Development Referral No. DN20/0063

Proposal: Environmental Impact Statement (EIS) for alterations and additions to President Private Hospital (SSD-10320).

Property: 369-381 President Avenue, Kirrawee

PMF Critical Storm Duration
Proposed Condition Water Velocity (m/s) - (Viewport 1)

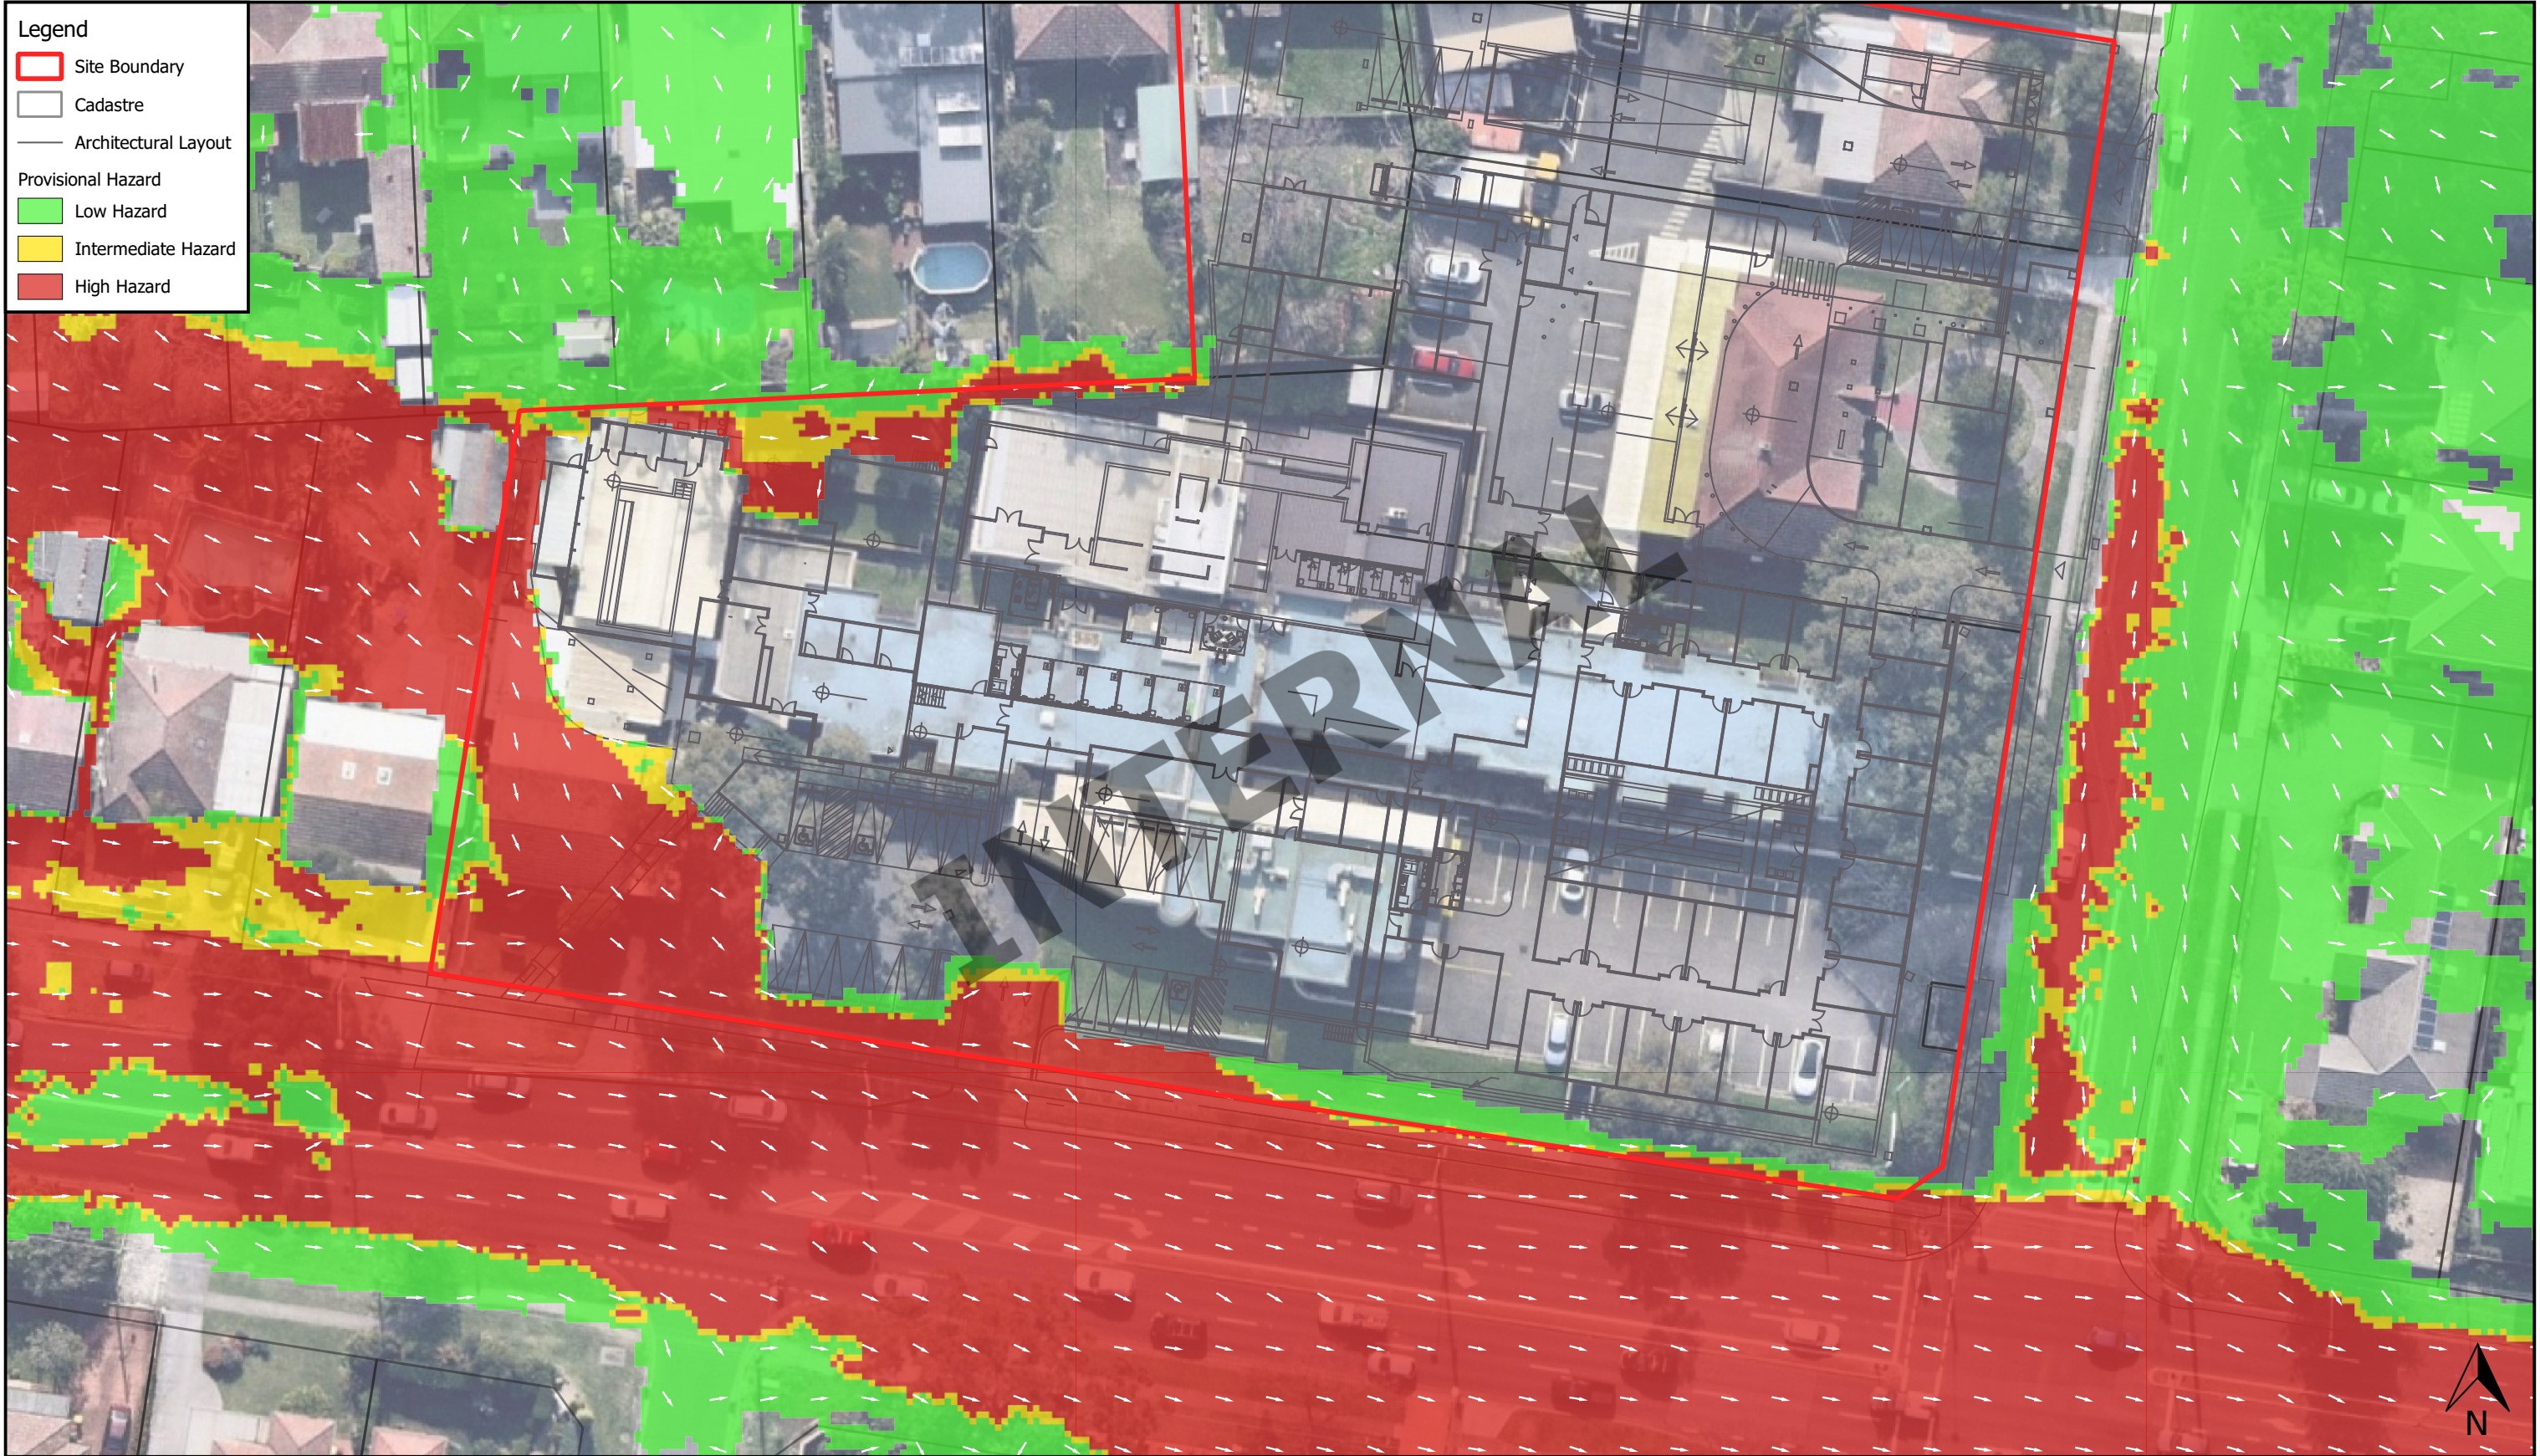
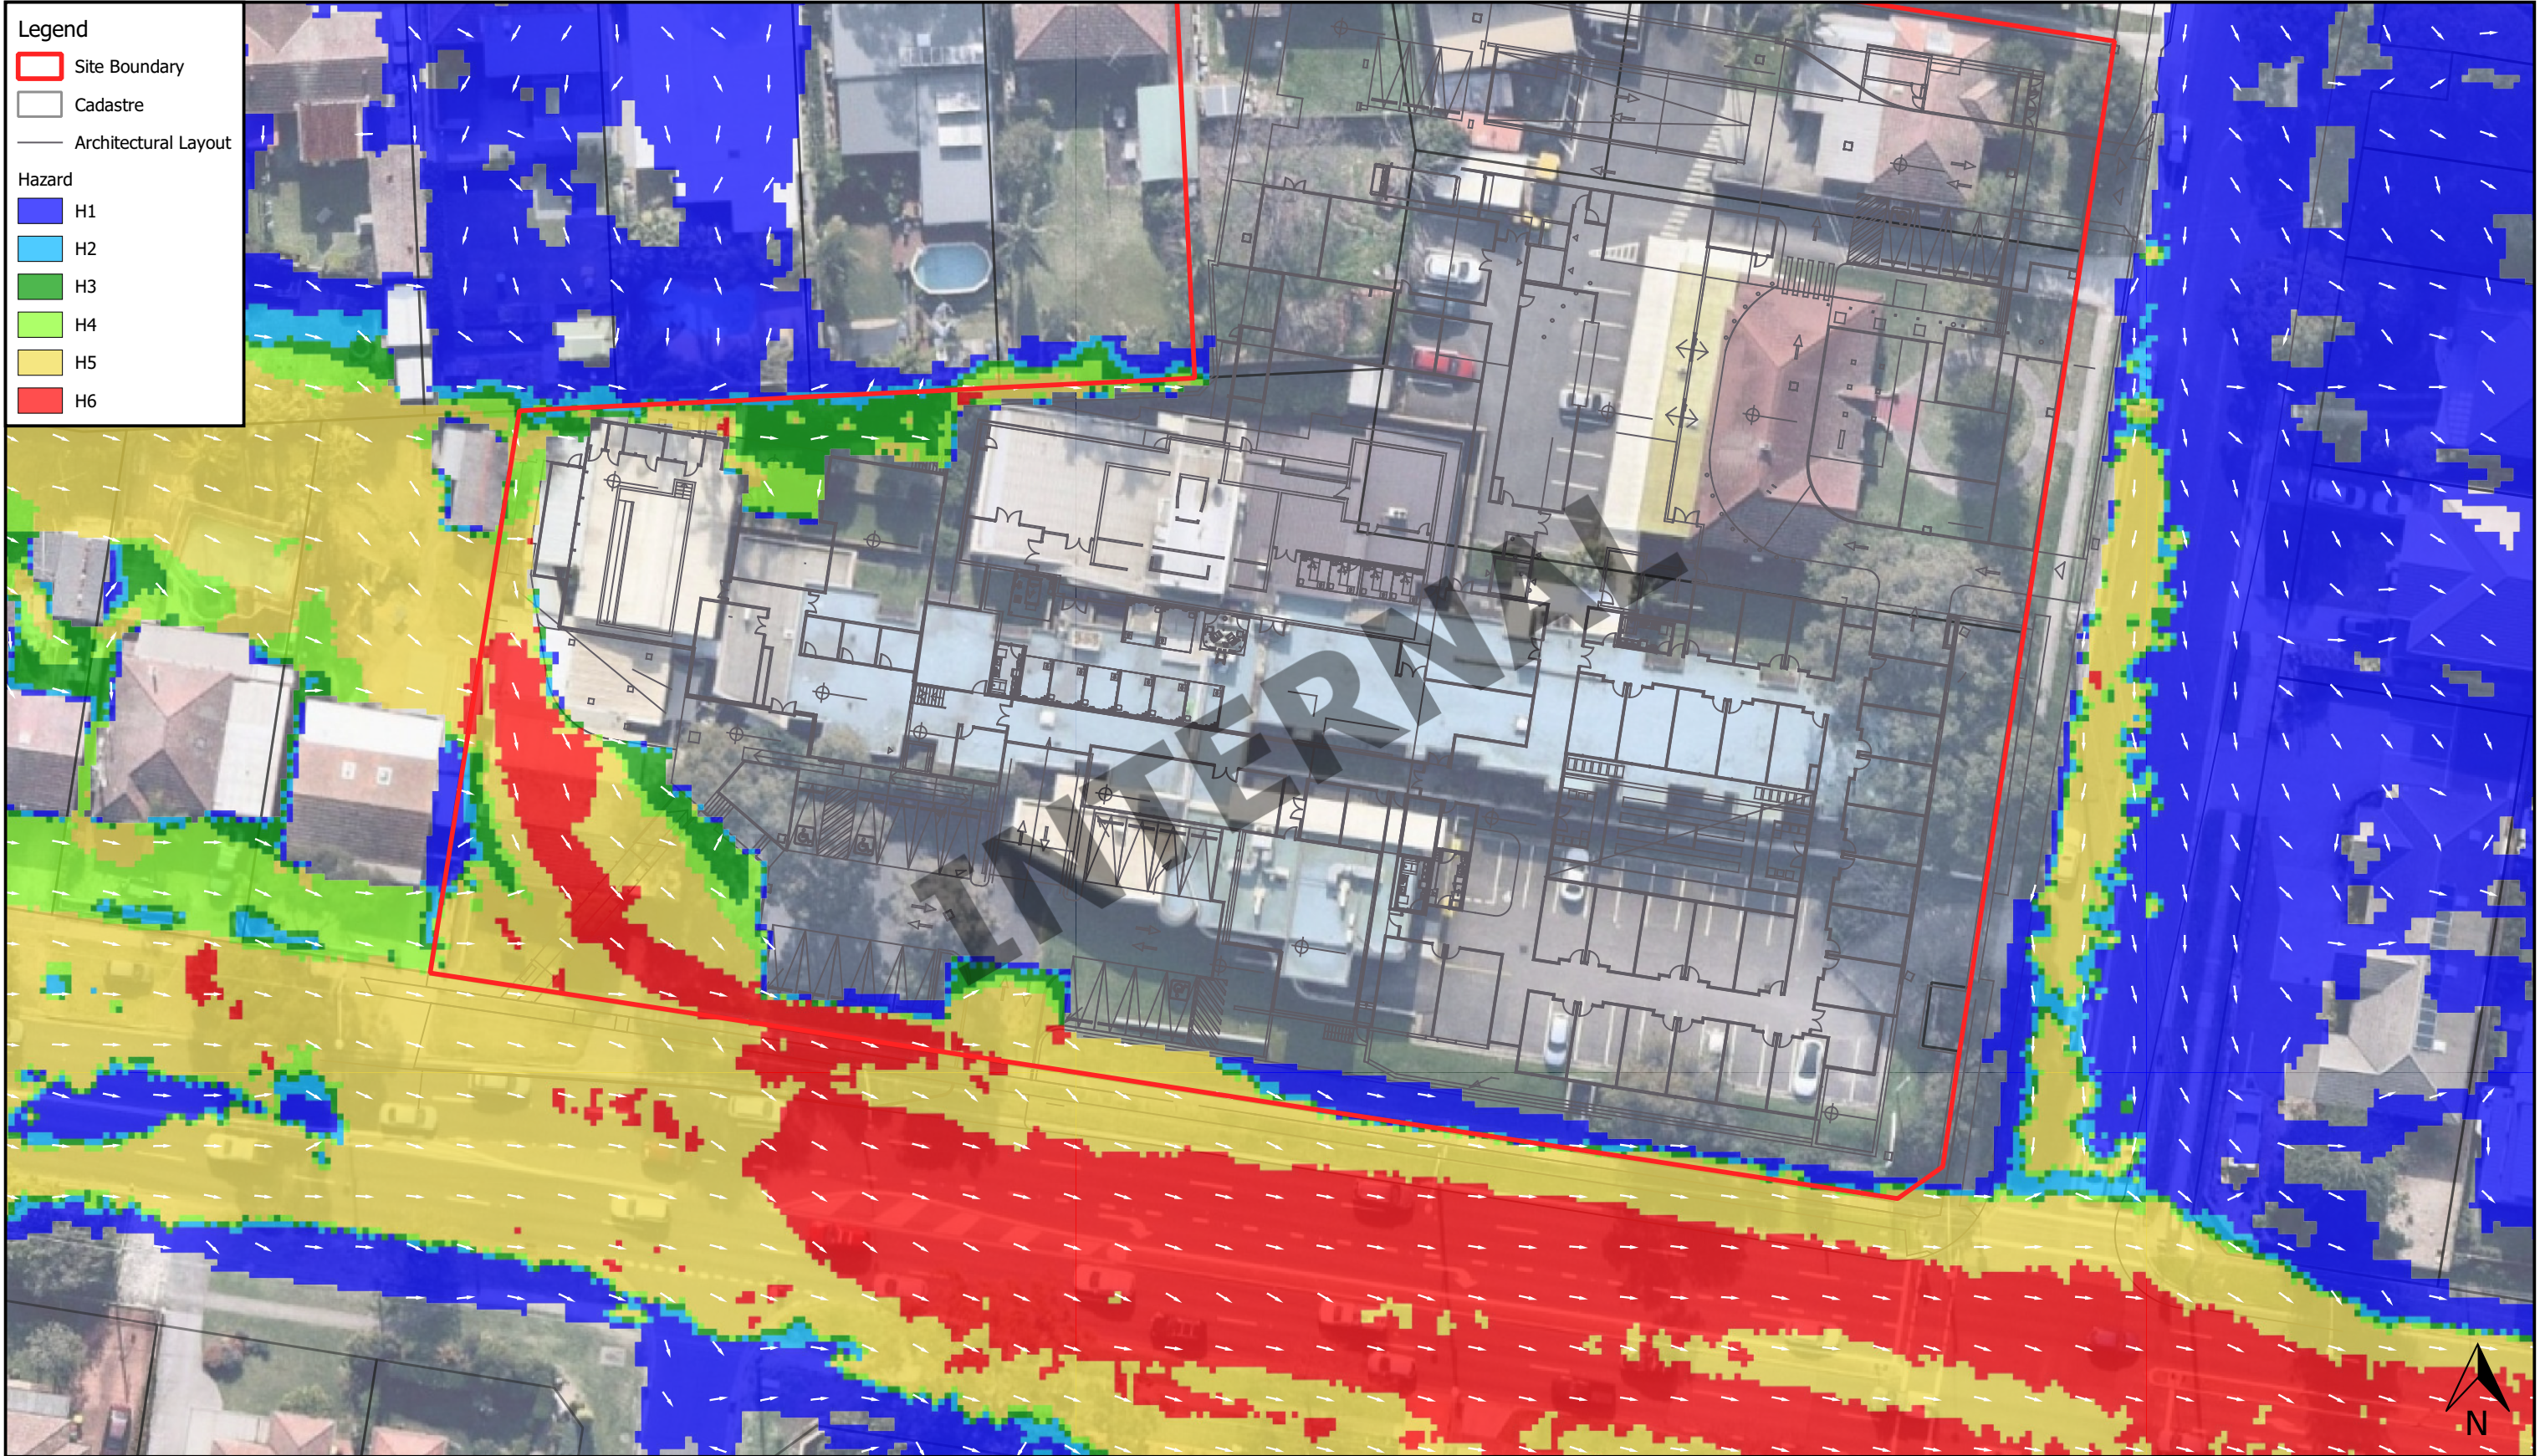
4. The hydraulic model does not account for Council's requirement for all inlet pits to be assumed 50% blocked.
5. The flood maps show flooding of the proposed car park in the PMF. Given the proposed development is an essential facility, greater protection from flooding is required. Hence, the basement driveway crest must be raised to the PMF level.

10. The flood maps show high hazard flooding of the proposed open car park in the PMF. Given the nature of the development, the open car park should be elevated so that it is not exposed to hazard causing damage to vehicles, hence should not fall within a hazard category higher than H2.

11. The crest of the driveway providing access to the basement should be elevated to the PMF level to provide additional protection.
12. Details of the proposed channel/swale should be provided and must be consistent with what has been modelled. Additionally consideration should be made to continuing the channel to the east toward the intersection at Hotham Rd and President Ave. In doing so, the channel should contain high hazard flooding within the property for an extended length before discharging onto the carriageway. This would reduce the risk to life and property damage within President Avenue. The applicant should consult with the SES and NSW Police to confirm that this would assist during a flood emergency.

2 Section Along Easment
1 : 200

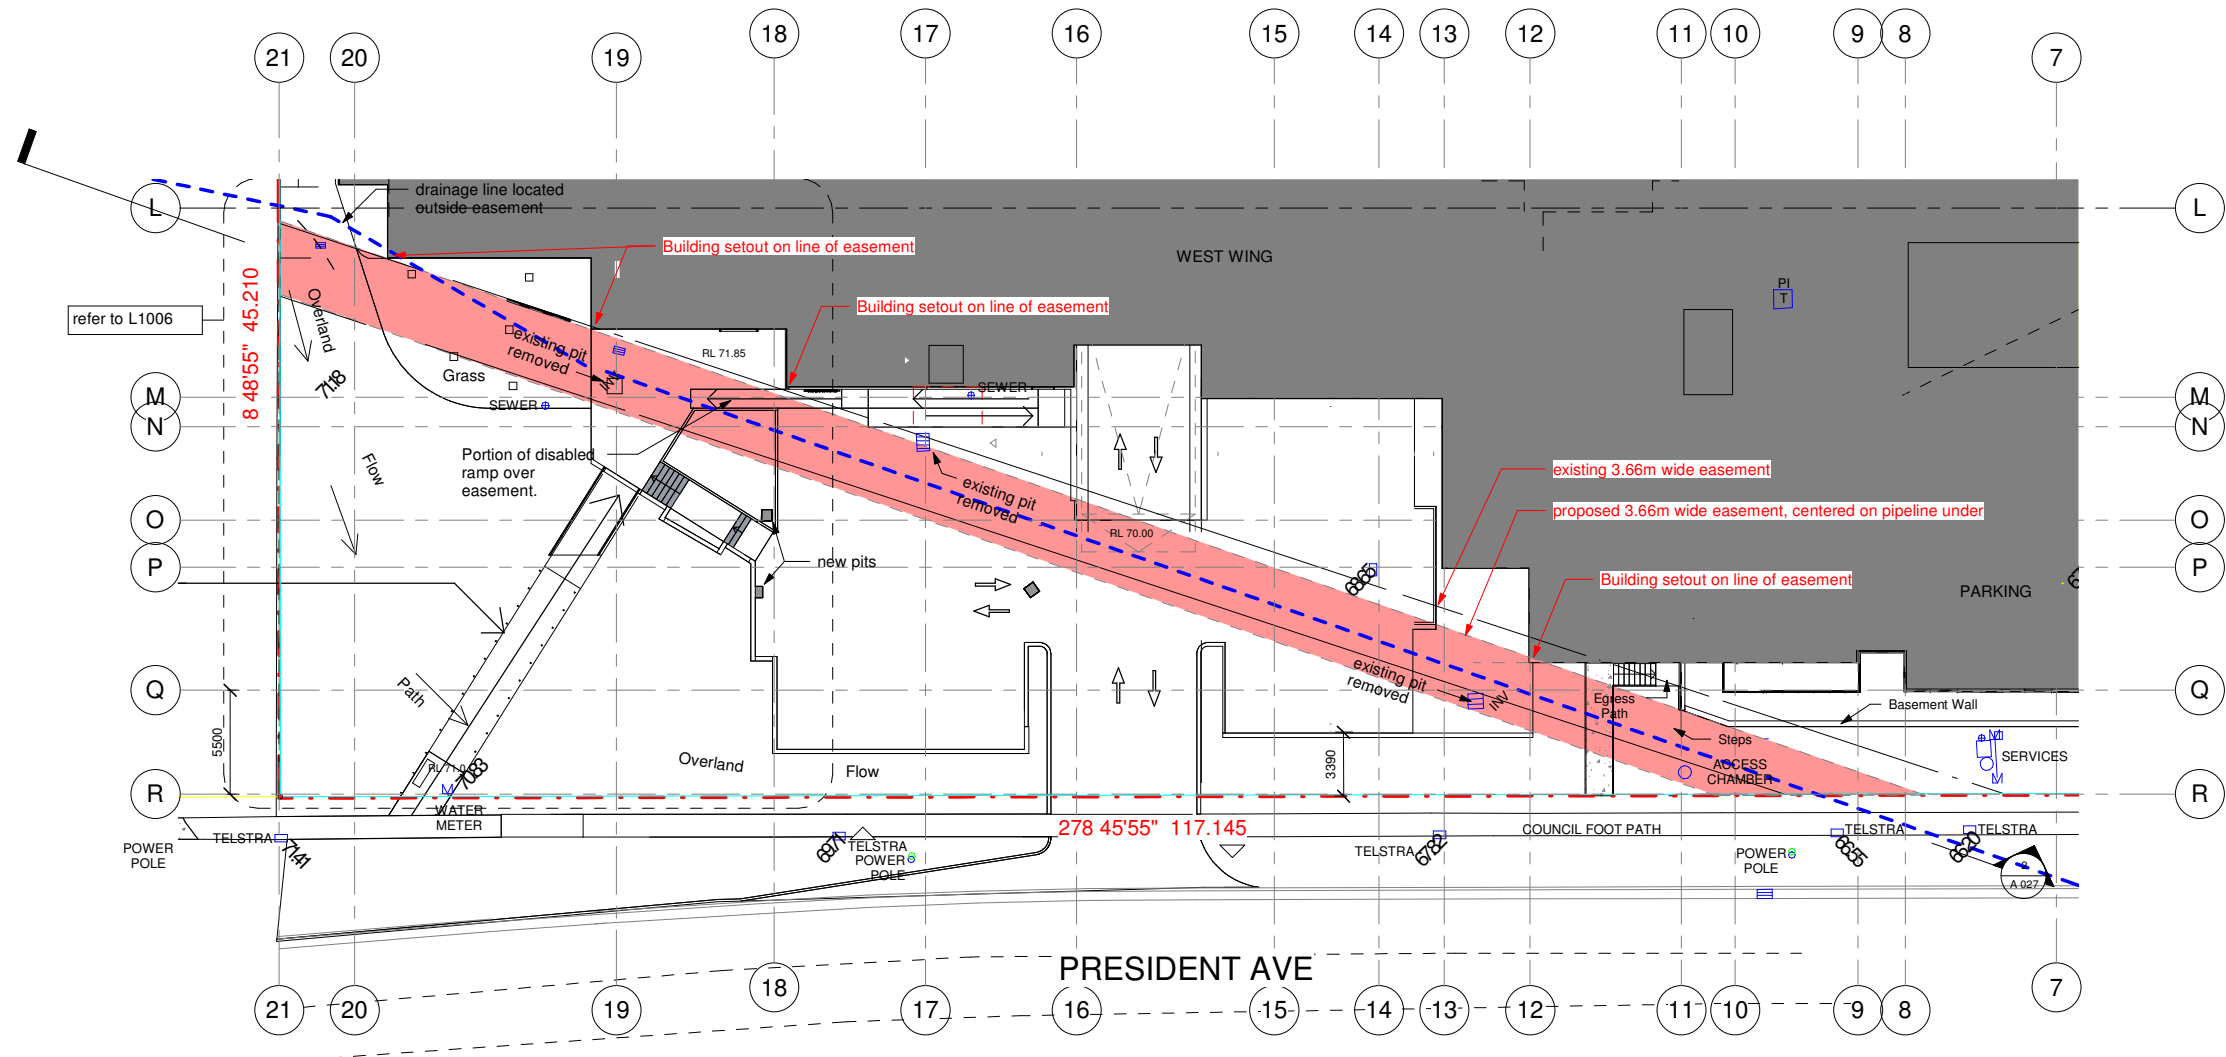
The submitted civil engineering plans show the Council drainage easement to be redirected over the pipeline. However, there is no information provided to support the easement relocation. The proposal to relocate the easement must be supported by empirical evidence of the location of the existing stormwater pipe including CCTV, site survey, and photographs.

Additionally, the plans show numerous structures over the proposed easement and existing stormwater line. The structures include retaining walls, private stormwater lines and other minor structure. Council will not accept any private structures over its easement.
